# CITY OF PORTLAND BUILDING PERMIT

Job ID: 2012-01-3060-CH OF USE

has permission to Establish the use of Bldg #3, Unit #4 & 5 as warehouse/office with alterations to the mezzanine provided that the person or persons, firm or corporation accepting this permit shall comply with all of the provisions of the Statues of Maine and of the Ordinances of the City of Portland regulating the construction, maintenance and use of the buildings and structures, and of the application on file in the department.

## **Conditions of Approval:**

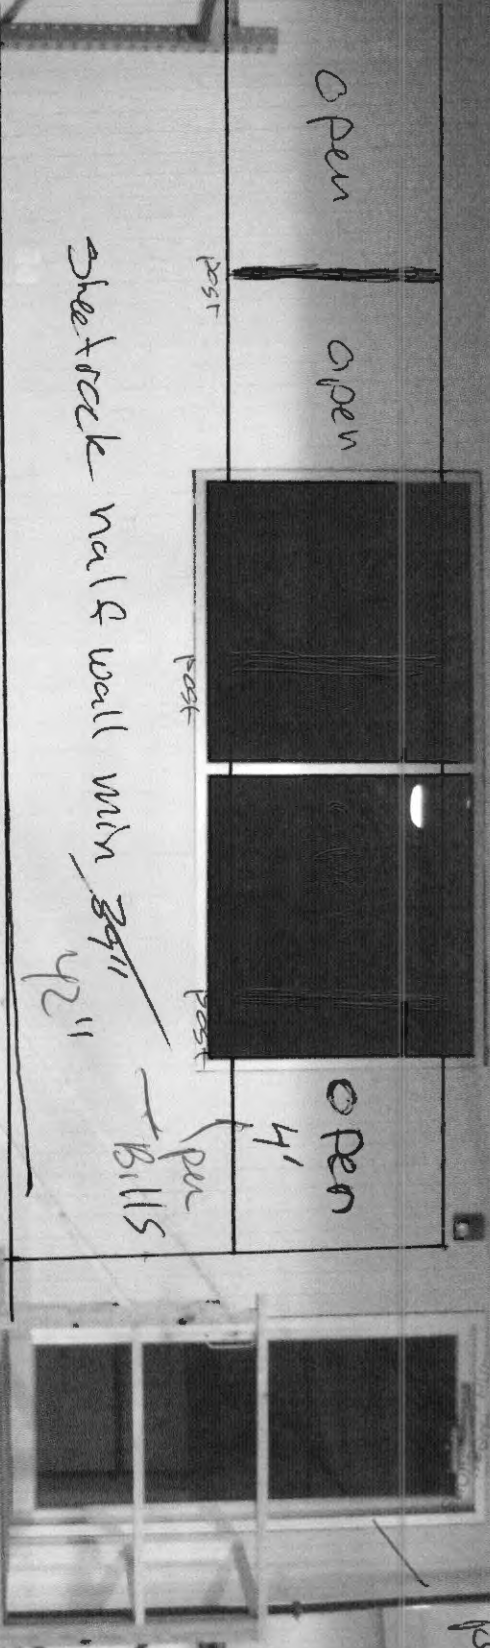
4/27/12 spoke w/ James (contractor) about the existing  
Guard - It is 36" at nosing - he is just adding balusters  
to L 4" and a cap ~~top~~ rail w/ mounted 36" graspable  
(returns) handrail. Guard is 42" at landing. Since this was  
existing at 36" it is allowed to remain. JMB

2. Permit approved based on the plans submitted and reviewed w/owner/ contractor, with additional information as agreed on and as noted on plans, including the stair guard and handrail heights & opening limitations.

- 1.) Remove existing sheetrock walls above 42" for entire interior perimeter
- 2.) Remove existing door
- 3.) Remove existing window 34"-38" returned both sides
- 4.) Install round hand rail at 42" from nose of stair tread to the base of the stairs
- 5.) Install spindles or plastic lattice below stairway railing to less than 4" openings for entire length
- 6.) Install spindles or plastic lattice below landing at the top of the stairway to less than 4" openings for entire area at 42" high
